Reference No:	2024/62/92731/E
Site Address:	631, Hunsworth Lane, East Bierley, BD4 6PU
Description:	Erection of first floor side extension and front porch
Recommending Officer:	Faiza Bano

HOUSEHOLDER DELEGATED REPORT

Application Number	2024/92731
Location	631, Hunsworth Lane, East Bierley, BD4 6PU
Proposal	Erection of first floor side extension and front porch
Publicity end date	11 th November 2024
Number of representations received	None
Kirklees Local Plan Allocation/Designation	Unallocated in the Kirklees Local Plan.
Extension to Time (EoT)	No
Recommendation	Conditional Full Permission

REAR

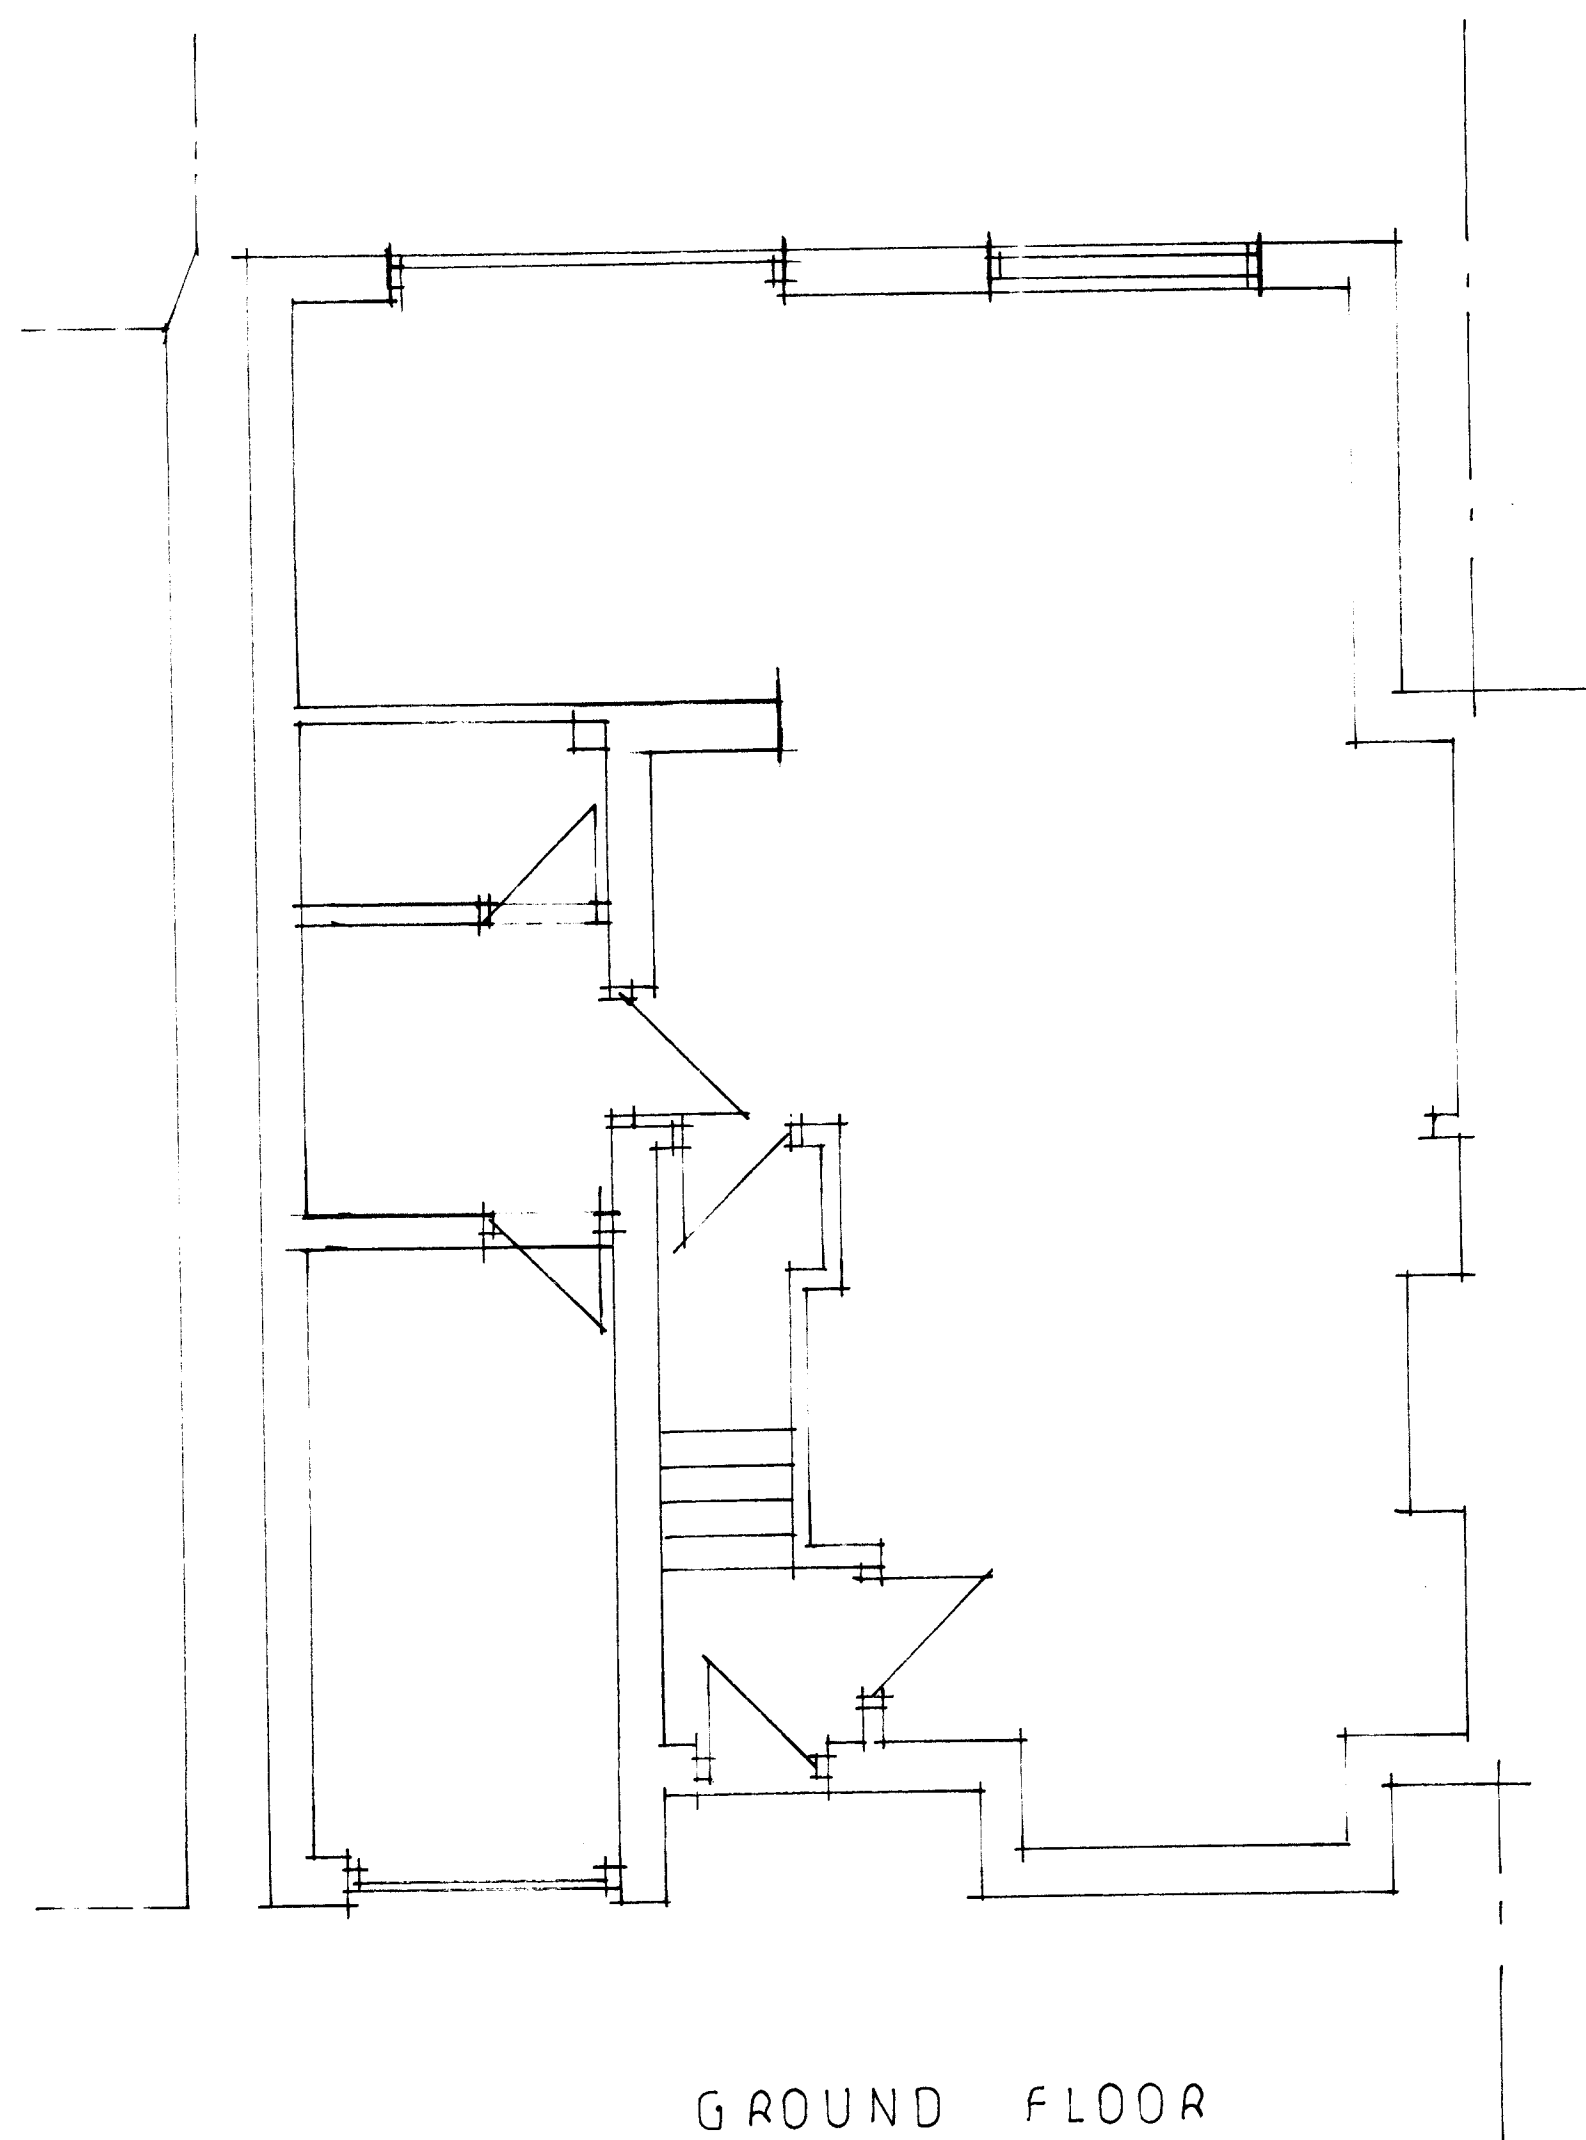
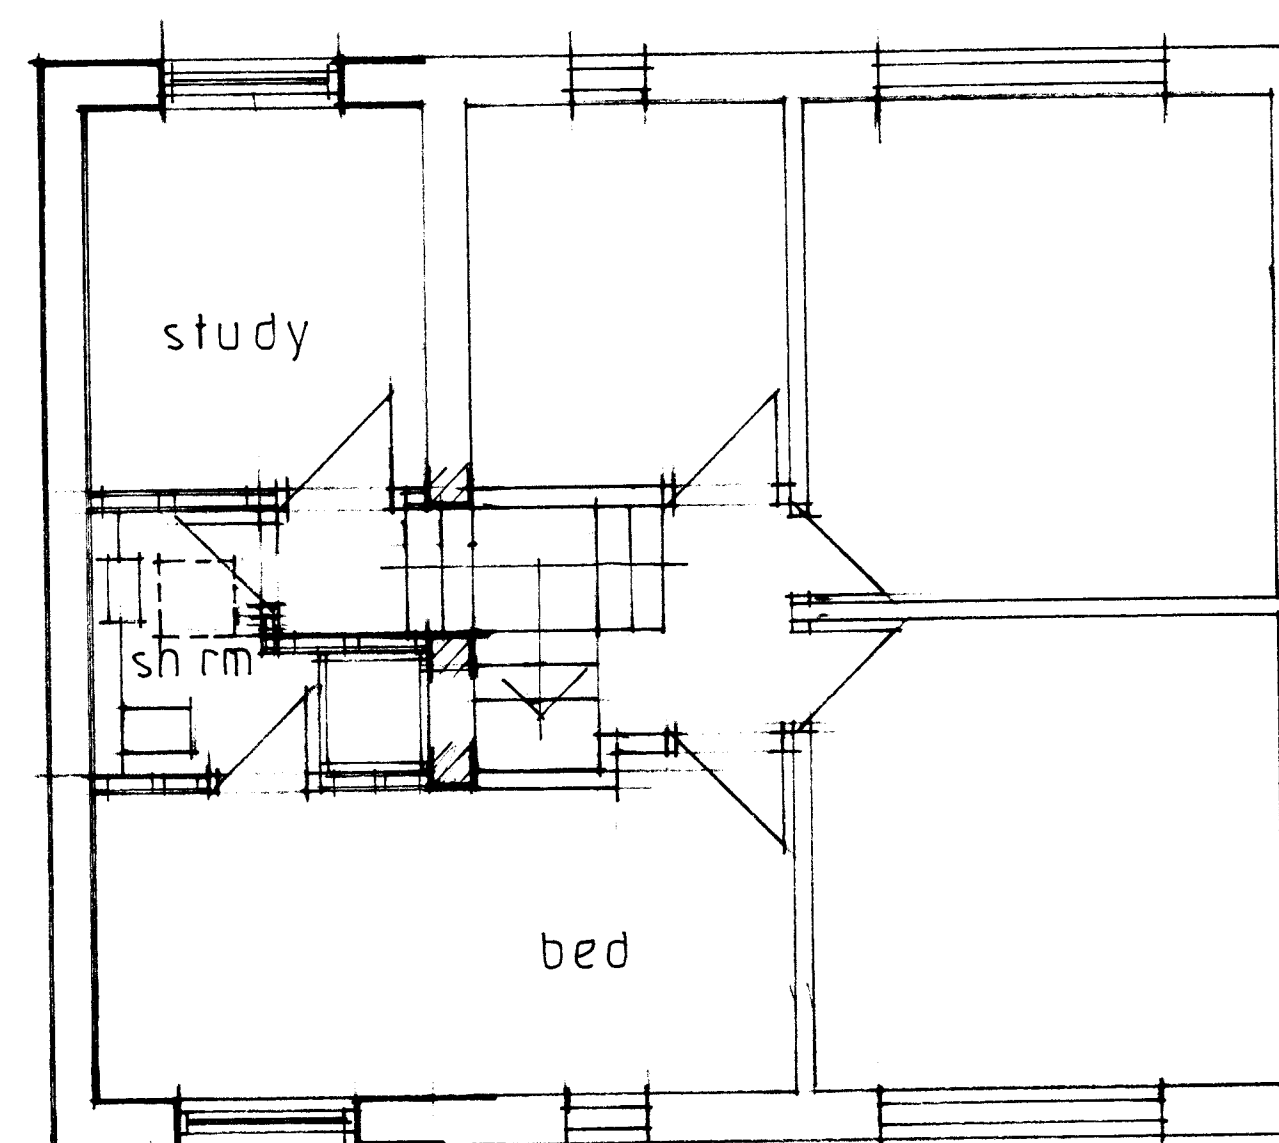
Side extensions should:	<u>Yes - COMPLY</u>	<u>No - JUSTIFY</u>
Ensure reasonable levels of natural light to the habitable rooms in neighbouring properties	Proposed extension is set back from the frontline of neighbouring property 629, it does not overshadow any windows of neighbouring properties, thus, ensures no significant impact to the levels of natural light neighbouring properties receive.

Positioning windows to minimise or avoid any potential overlook into neighbouring gardens	As the first floor of the property is set back from the front elevation of the ground floor and neighbouring dwelling, the outlook from the proposed bedroom window will have no significant impact upon the neighbouring property.	
Two storey side extensions should:		
Not take up all or most of the space to the side of a house		The first-floor extension would not be small in size but remain subservient to the existing building on site. The width of this extension would be limited to the width of the existing single storey side extension. It is also noted that several semi-detached properties nearby have had an extension of a similar size, including the adjoining semi. The proposed side extension would mirror this and balance the symmetry of the pair. Acknowledging that, it is considered that the scale of development as proposed could be supported from a visual amenity perspective in this instance.

maintain a 1 metre gap to the side boundary to ensure the building is not too close to a neighbouring property		As outlined above, whilst not maintaining a 1m gap, the lack of a gap of this scale has been established by the existing ground floor

side extension and is therefore acceptable in this instance.
be set back at least 500mm from the front wall of the house		The proposal is not set back from the front wall of the house, however, the neighbouring property, 629, has erected a similar two-storey extension that also lies flush with the front elevation of the building. As a result, the proposed extension would not adversely affect the character of the street and is acceptable in this instance.

Single storey front extensions:	<u>Yes - COMPLY</u>	<u>No - JUSTIFY</u>
The house is set well back from the pavement or is well screened; and	Yes – the house is well setback from the pavement. It benefits from a front garden that includes a drive way.	
The extension is small, subservient to the original building, well-designed and would not harm the character of the original house or the area; and	Yes – the extension would appear subservient and has been designed with a pitched roof, in-keeping with host property.	
The materials and design match the existing features of the original house; and	Yes – materials would match existing	
The extension would not unreasonably affect the neighbouring properties.	Yes – the modest scale would result in minimal impact on neighbouring property.

Height, scale and massing	• KDP 1 and 2 of the SPD • Policy LP24 Design (a), (c) and (d) of the KLP • Chapter 12 of the NPPF	Two-storey in height and lies flush to the original building, appearing proportionate to the host property.	✓
Facing materials and detailing	• KDP 9 of the SPD	Brickwork and uPVC doors and windows are to be used, matching the existing building.	✓

• Policy LP24 Design (d) (iii) of the KLP • Chapter 12 of the NPPF		
Roof style	• KDP 1 and 2 of the SPD • Policy LP24 Design (a), (c) and (d) of the KLP • Chapter 12 of the NPPF	A tiled roof will be used on the extension to match the existing building.	✓
Window proportions	• KDP 1 and 2 of the SPD • Policy LP24 Design (a), (c) and (d) of the KLP • Chapter 12 of the NPPF	Proposed uPVC windows and doors to the front and rear of the property are in proportion with those existing and well-aligned.	✓
Accessibility for all users	• KDP 17 of the SPD • Policy LP24 Design (f) • Chapter 12 of the NPPF	Private domestic extension – no amendments are to be made regarding accessibility.	✓

• 629 Hunsworth Lane – Adjacent property and shall see the construction of a first-floor extension, to include a window in the front elevation, and the erection of a front porch. 629 Hunsworth Lane has a similar extension and due to the space and relationship no issues would arise from overlooking, overshadowing/loss of light or overbearing impact.

SITE PLAN
Scale 1:500
dra no: 24/116

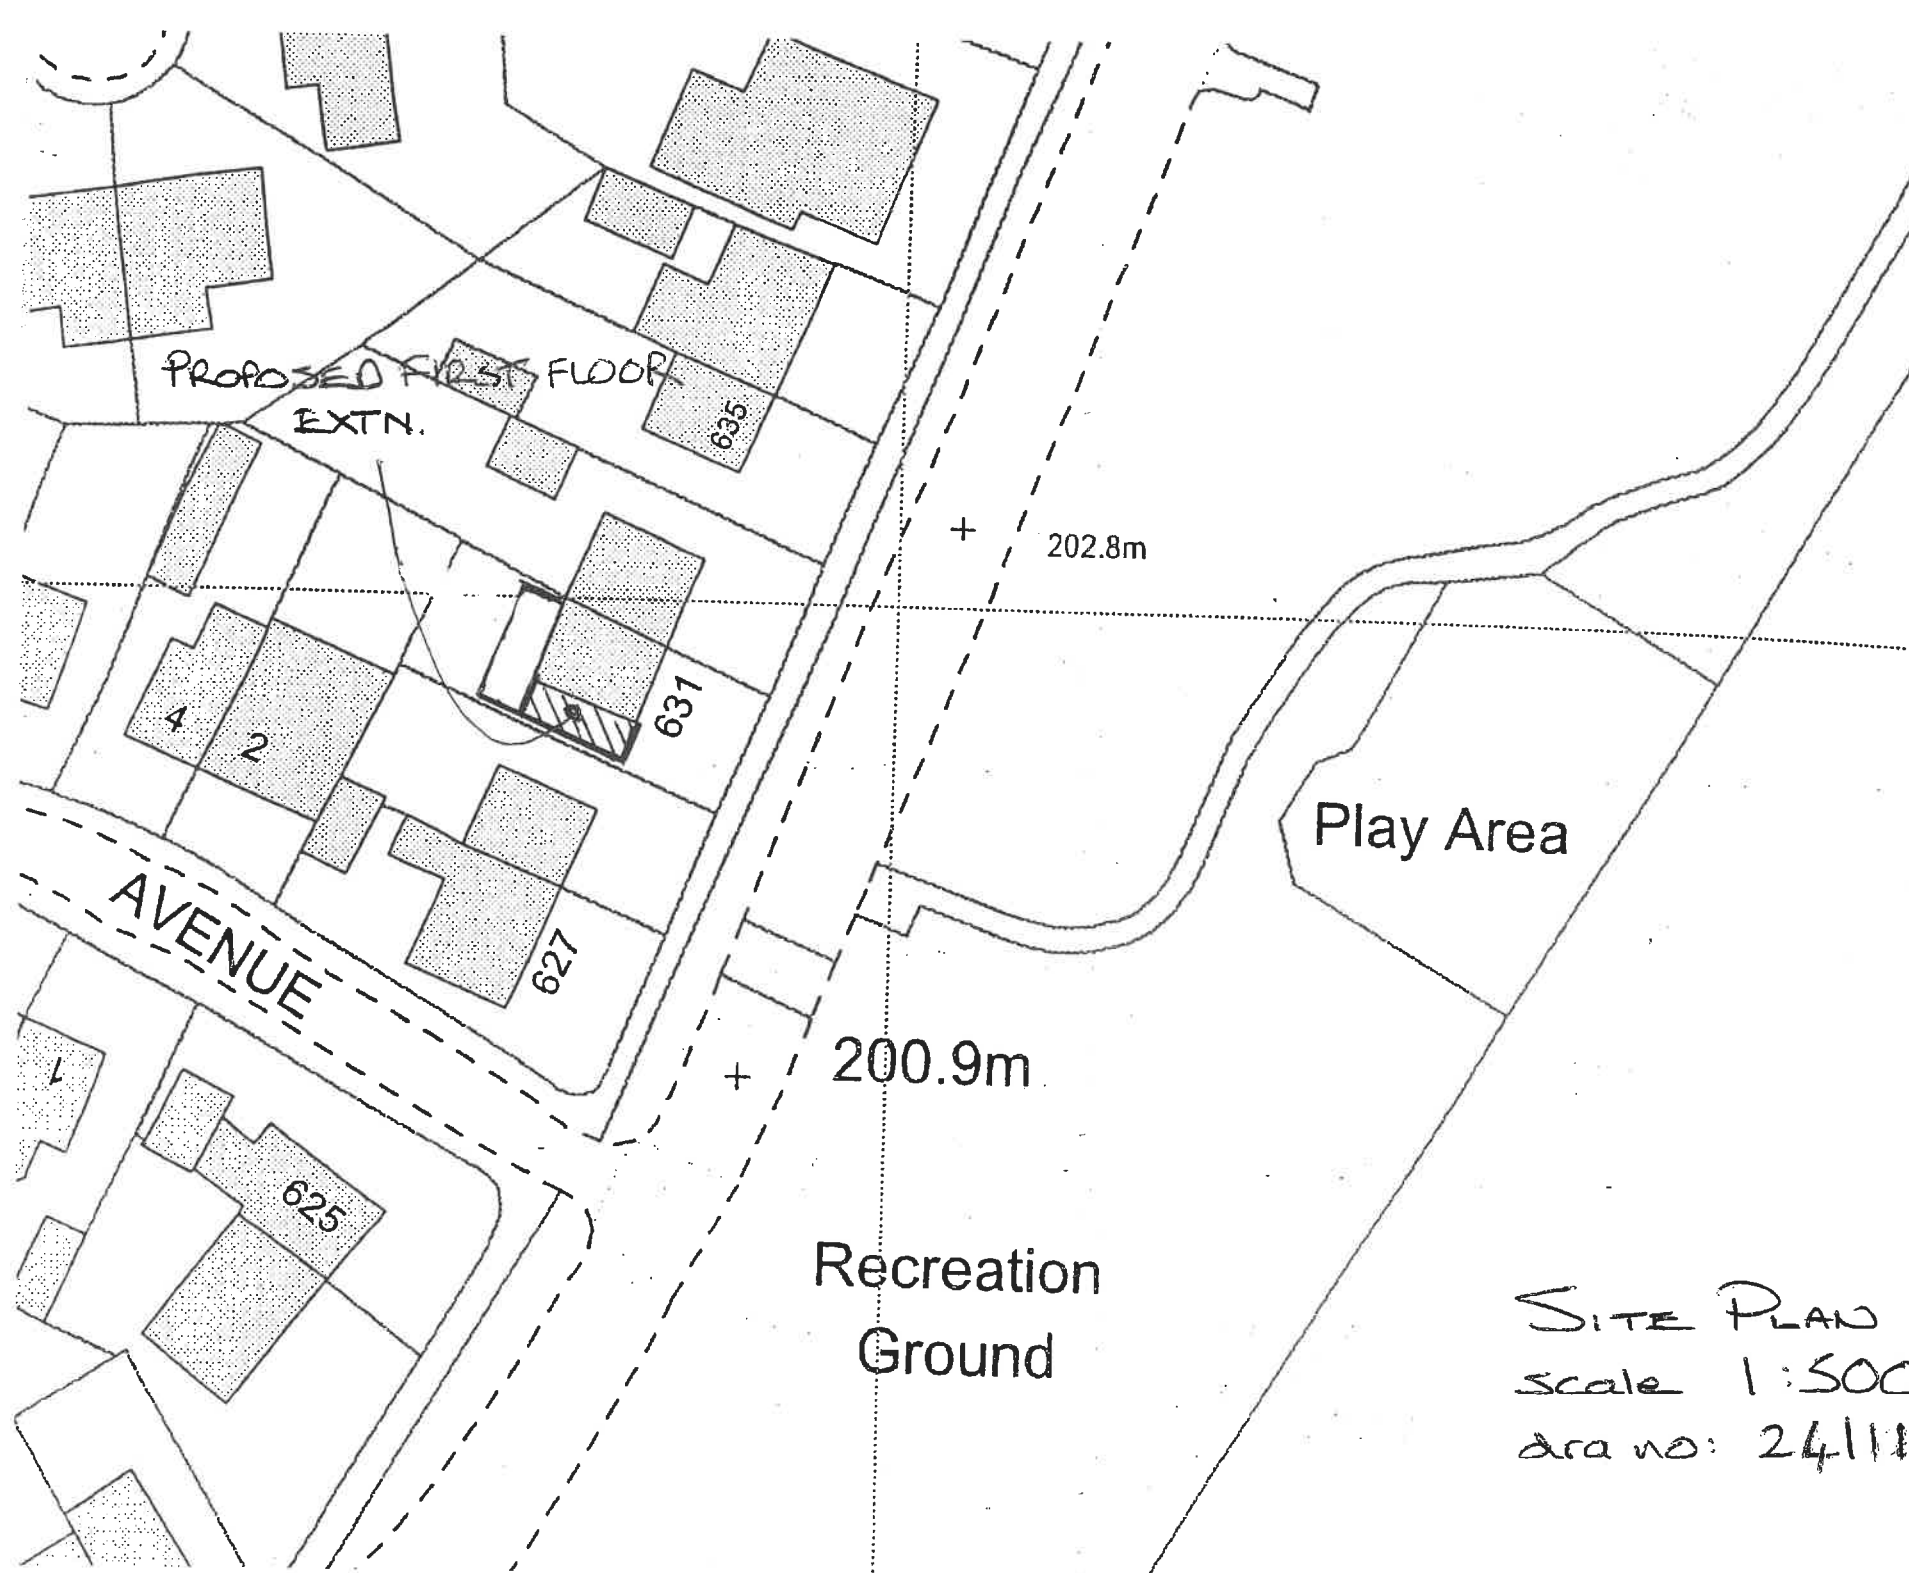
Relevant key design principle (KDP) of the SPD, Policy in the Kirklees Local Plan and the NPPF	Further comments	✓ / X / N/A
Impact on highway safety	• KDP 15 of the SPD • Policy LP22 Parking (f) of the KLP • Chapter 12 of the NPPF	The building is set back far enough from Hunsworth Lane to have no significant impact upon highway safety.	✓
Parking provision	• KDP 15 of the SPD • Policy LP22 Parking (f) of the KLP • Chapter 12 of the NPPF	Maintains appropriate access and parking.	✓
Provision for waste storage	• KDP 16 of the SPD • Policy LP24 Design (d) (iv) Chapter 12 of the NPPF	There is nothing specific outlined in the plan, however, there is enough space on the site to facilitate adequate waste storage.	✓
